## **SUMMARY OF REGULATION 19 ISSUES FOR BROADWATER ROAD WELWYN GARDEN CITY- 3.11.2010**

It is considered that a Regulation 19 notice should request the following clarification / additional information:-

BROADWATER ROAD WEST, WELWYN GARDEN CITY
 DETAILED PROPOSALS: ENERGY CENTRE
 PROPOSED GENERAL ARRANGEMENTS
 568_07_165
 SCALE: 1:100 @A0 1:200 @A2

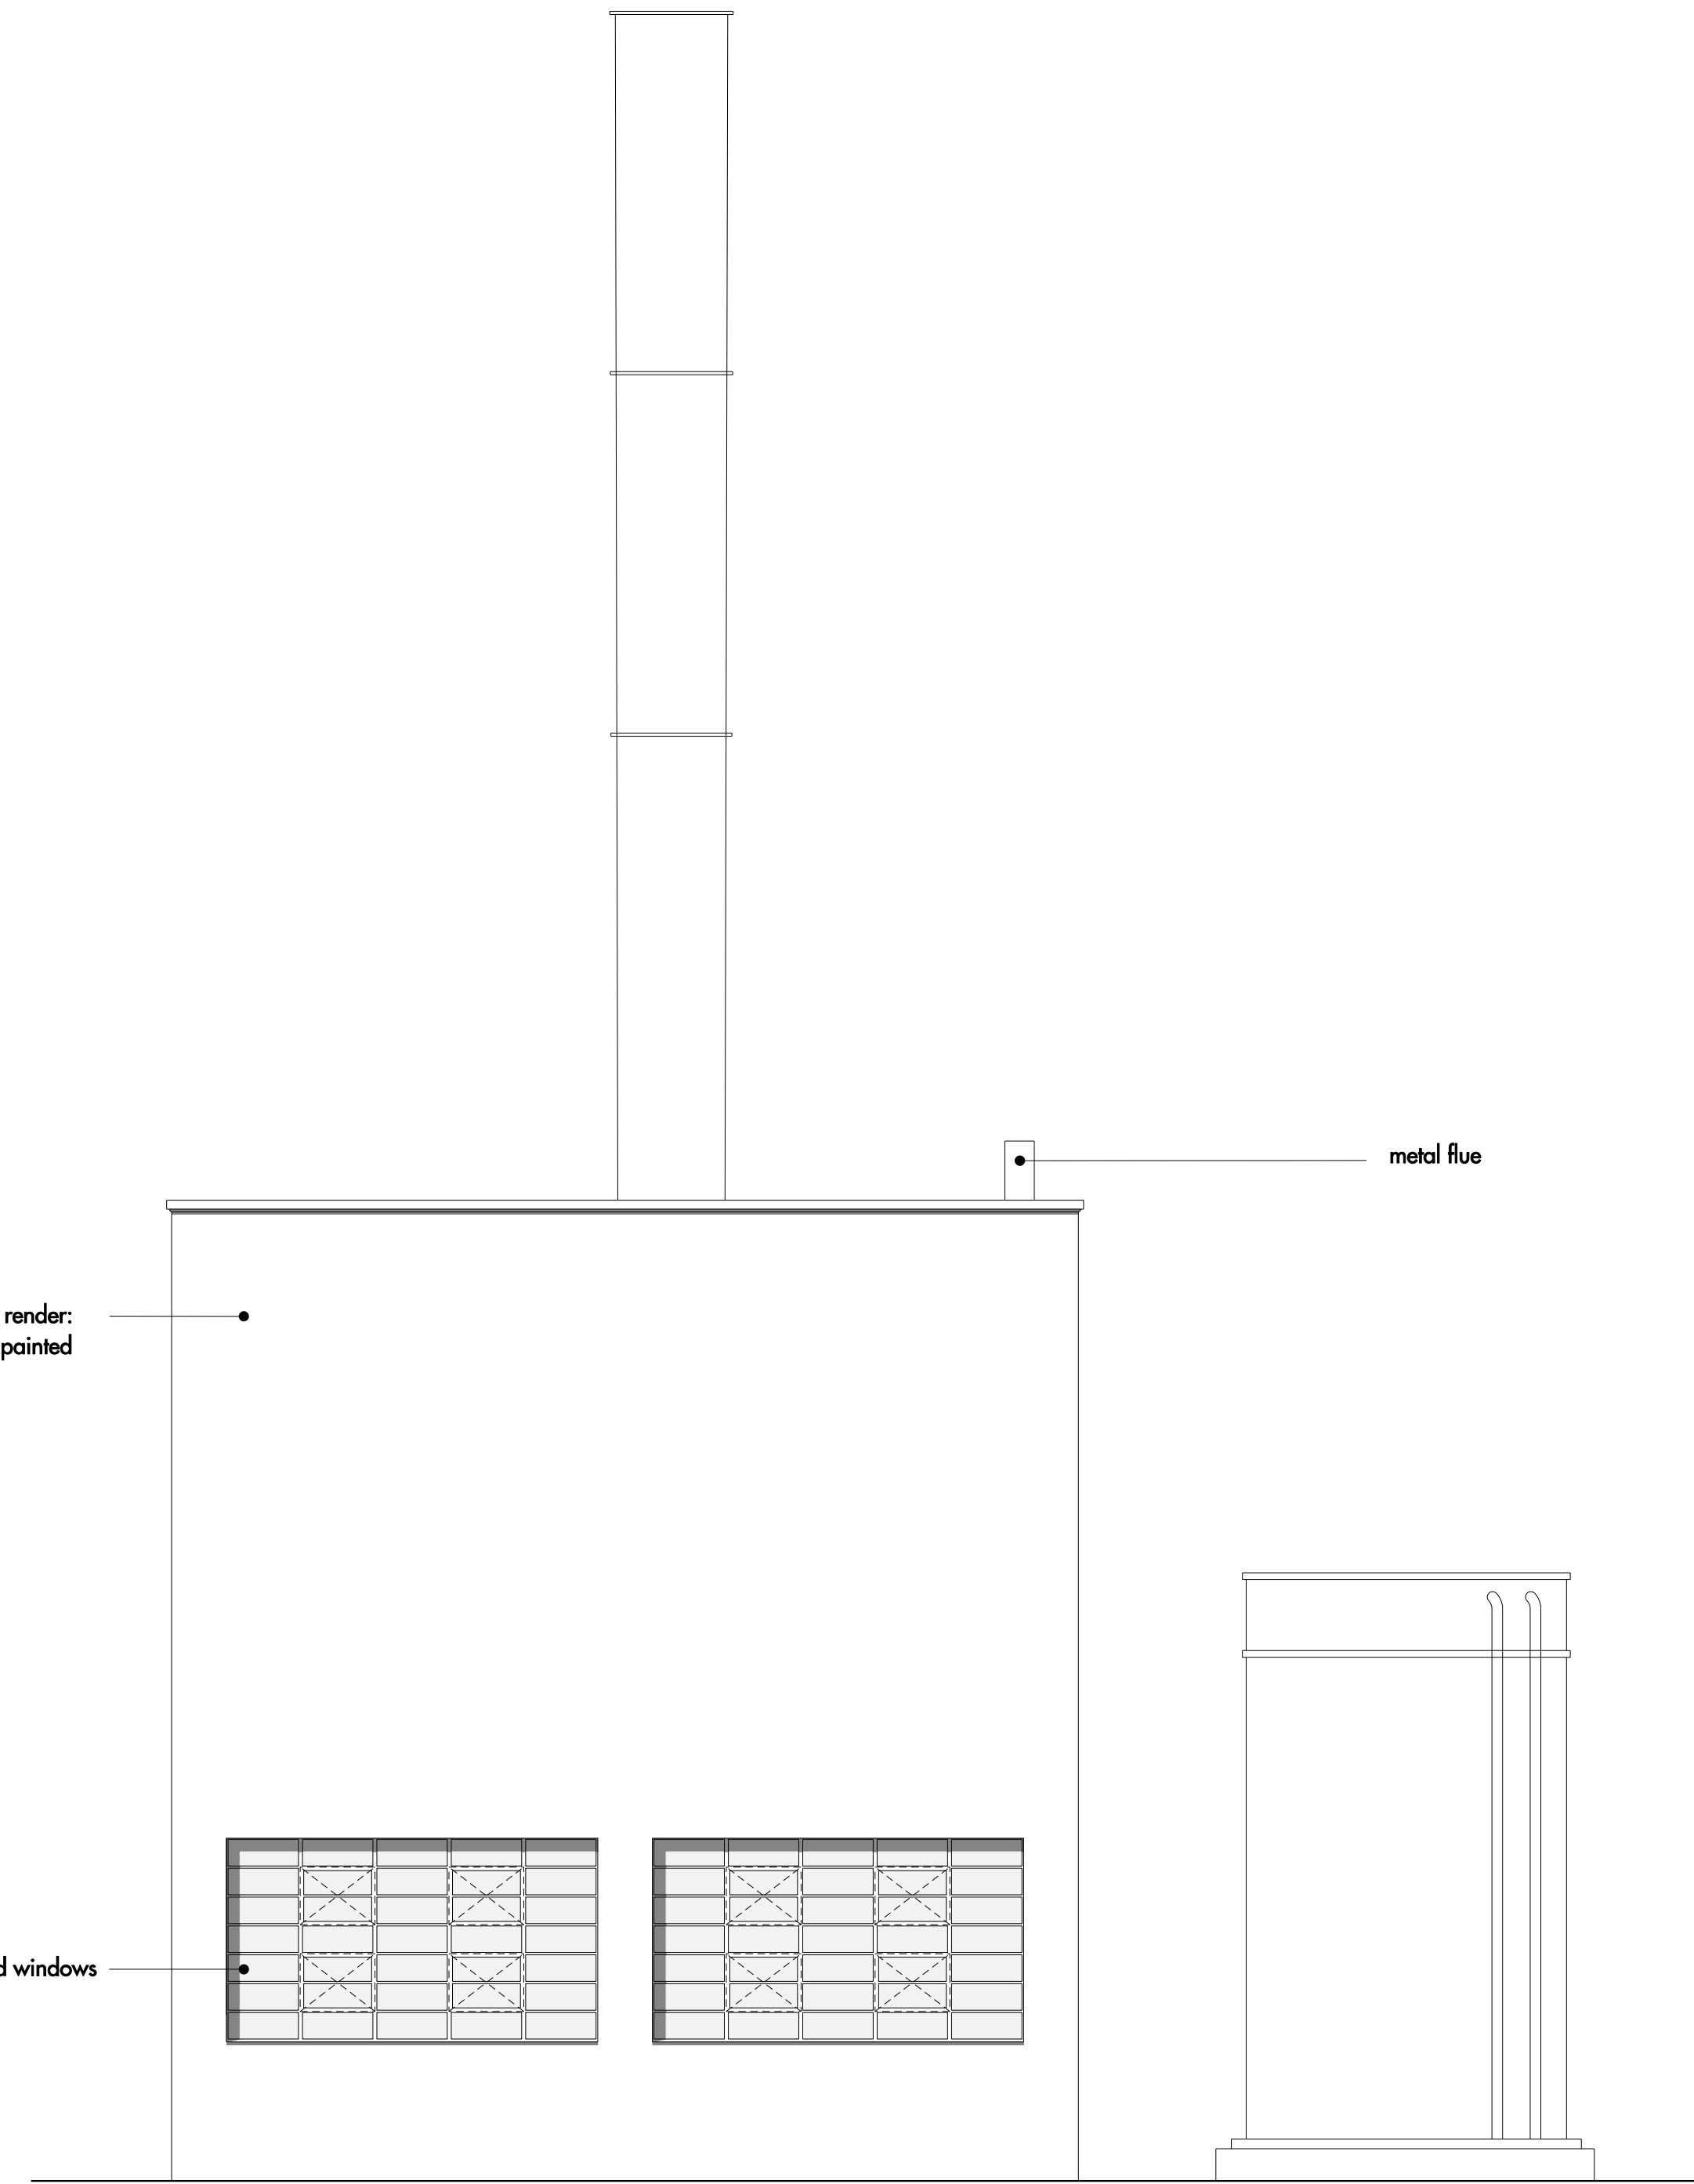
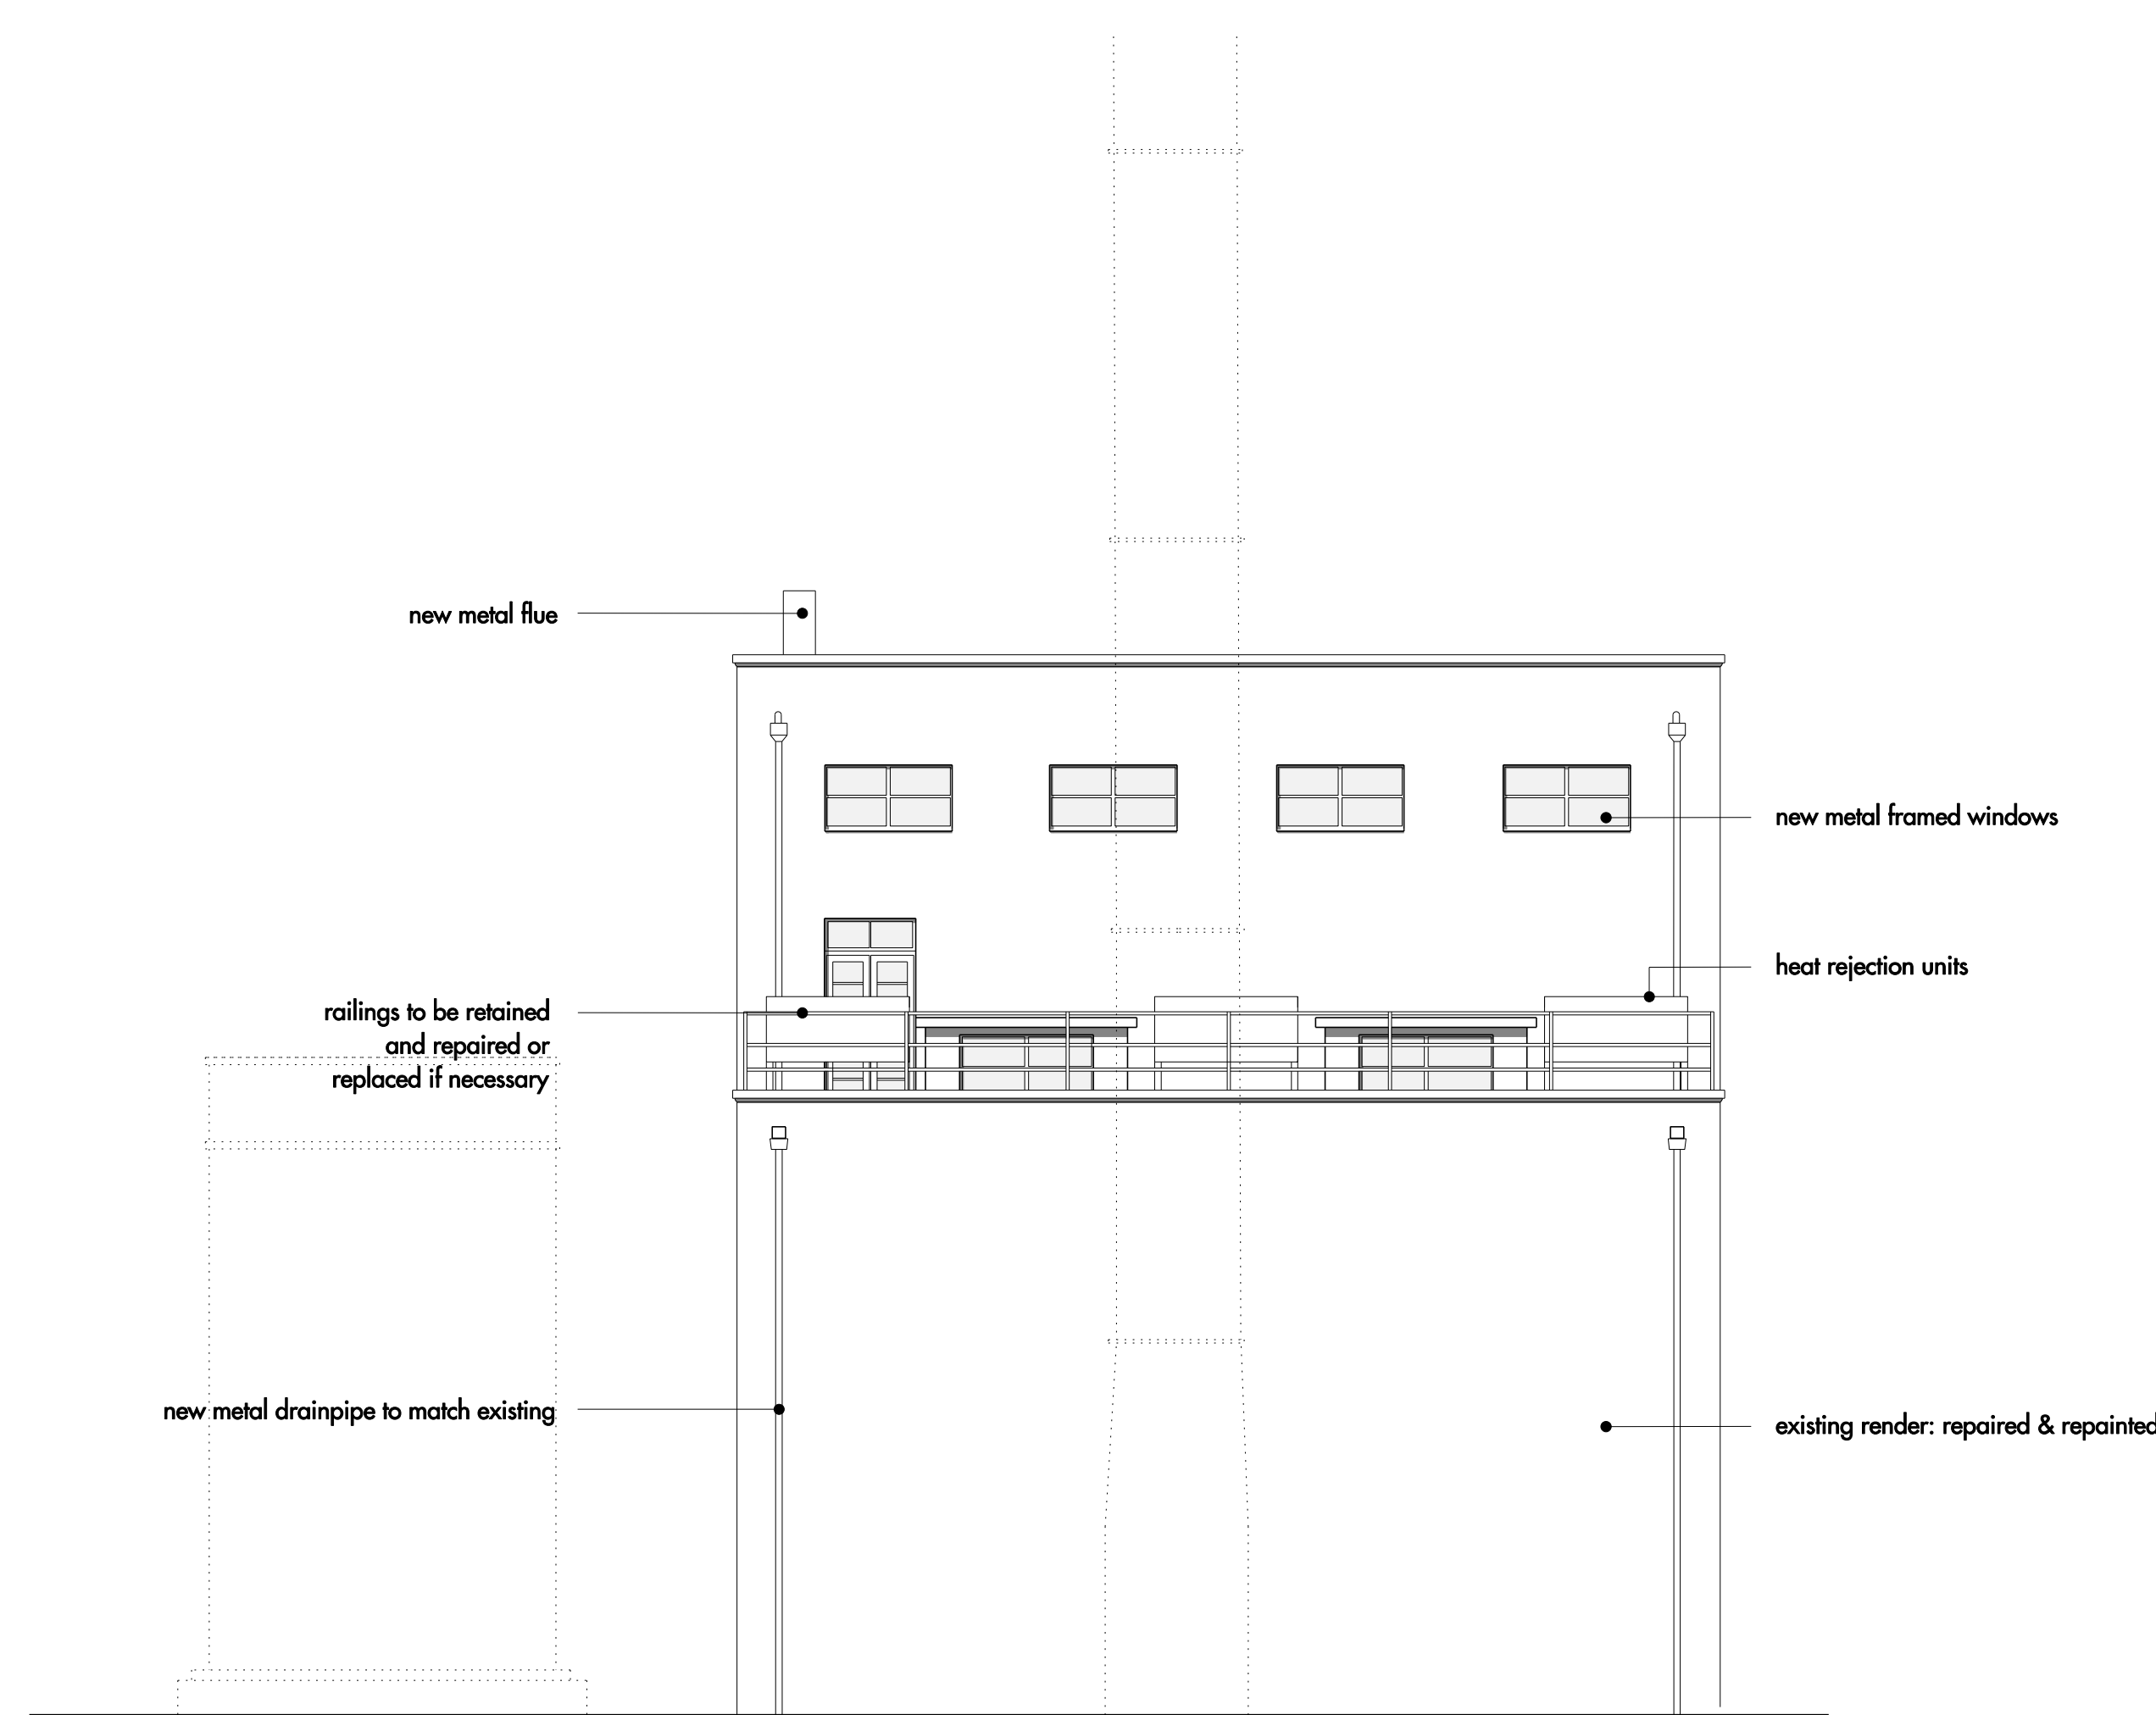
Confirmation is needed on the fuel type proposed for the CHP, and whether or not the CHP will serve the whole development. Confirmation is also needed as to whether the existing building and stack proposed to be re-used for this purpose will be adequate to house all of the plant required. Confirmation should be provided of the air quality, noise and visual impacts that will result from the CHP, as nearby residential units and other uses which may be adversely affected by the CHP lie within the area of the detailed application.
